**Rezoning Transportation Analysis**  
**Petition Number: Insert Zoning Petition # 2021-031**  
*General Location Identifier: Tax ID 15503211*

Date	Description
03-25-2021	First Review (WB)
04-19-2021	Second Review (WB)

The petition is located adjacent to South Laurel Avenue, a City-maintained minor thoroughfare, 120 feet east of Willoughby Street, a local road. The petition is in the South Wedge inside Route 4. Applicable area plans include the Elizabeth Area Plan.

RZ1.00

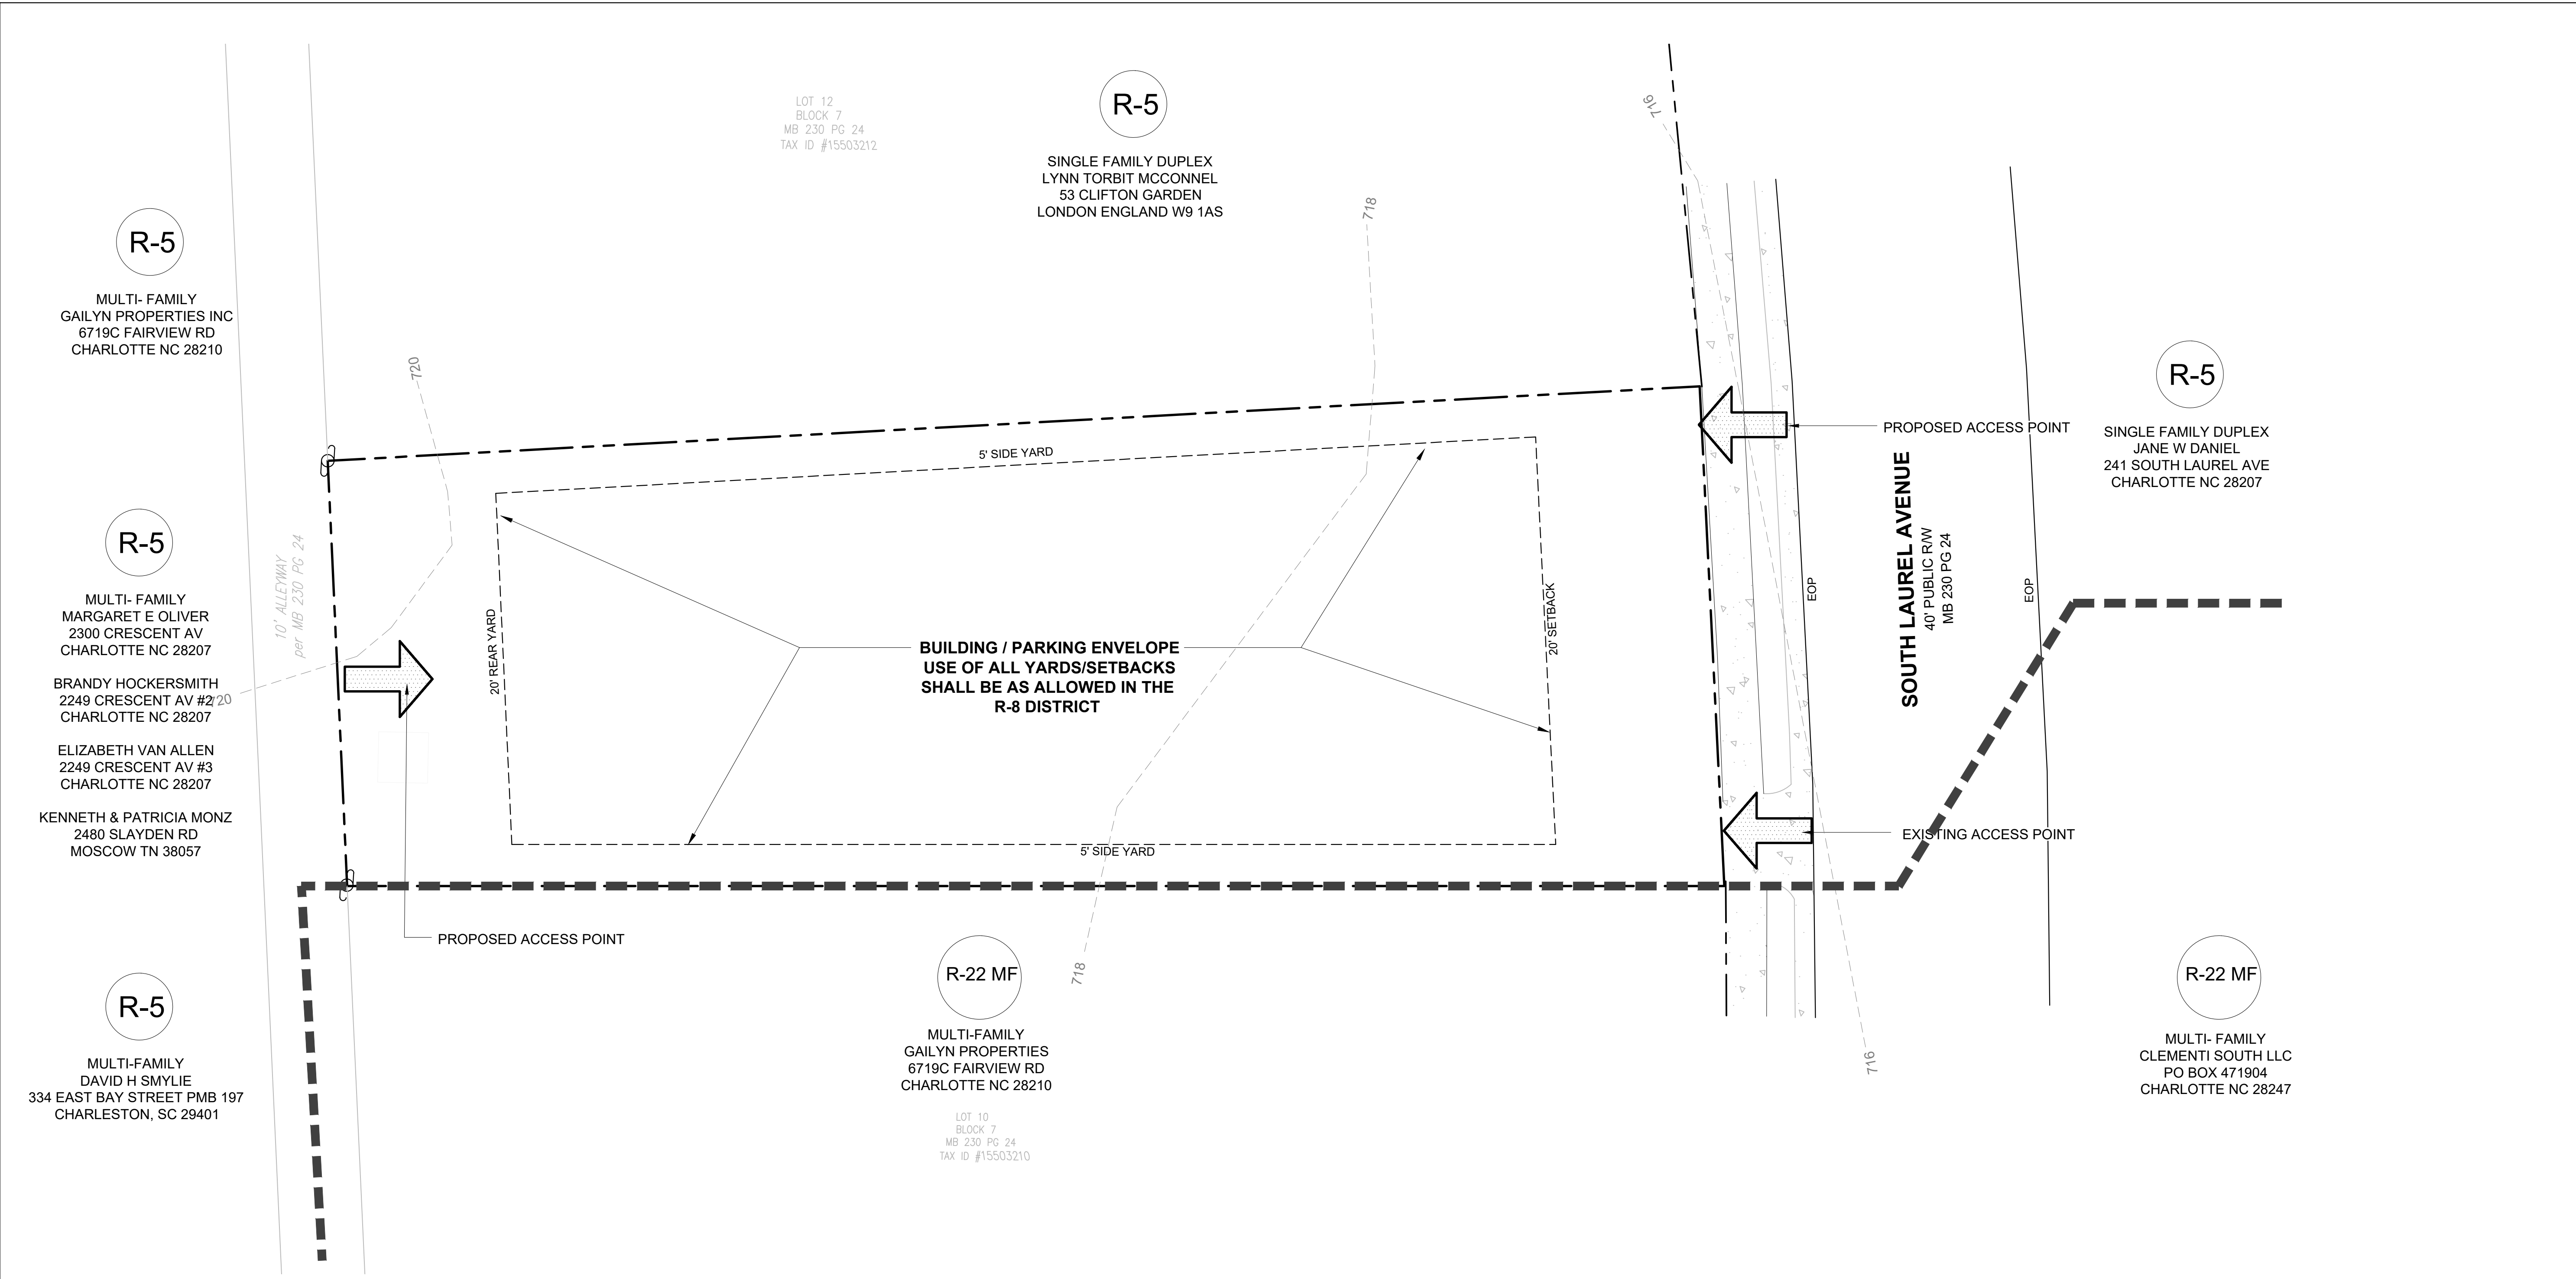
1. ~~**Curblin**~~: The proposed zoning district has a setback measured from back of the existing or proposed future curblin.

a. ~~**South Laurel Avenue**~~: The future location of curb and gutter is in its existing location.

Label and dimension the curb and gutter from the centerline for each road on the site plan.

3. ~~Revise site plan and conditional notes to commit to dedicate 30' right-of-way from the road centerline. The site plan shall label and dimension the right-of-way from the road centerline. **RESCINDED based on meeting held on 4/14/2021.**~~

4. ~~Revise site plan and conditional notes to commit to construct a 6-foot sidewalk and an 8-foot planting strip on South Laurel Avenue per CLDSM Standards 11.09. The site plan shall label and dimension both items from the back of curb and gutter and road centerline.~~

Reference CLDSM standard detail 11.09 for street typical. **RESCINDED based on updated site plan uploaded on 4/14/2021.**

5. ~~There are existing and proposed driveway access points along South Laurel Avenue. Please show the minimum distance between the two site access points on South Laurel Avenue. **RESCINDED based on meeting held on 4/14/2021.**~~

6. ~~Add a site plan note specifying dedication and fee simple conveyance of all rights-of-way to the City before the site's first building certificate of occupancy is issued is needed. CDOT requests rights-of-way set at 2' behind back of sidewalk where feasible. **RESCINDED based on updated site plan uploaded on 4/14/2021.**~~
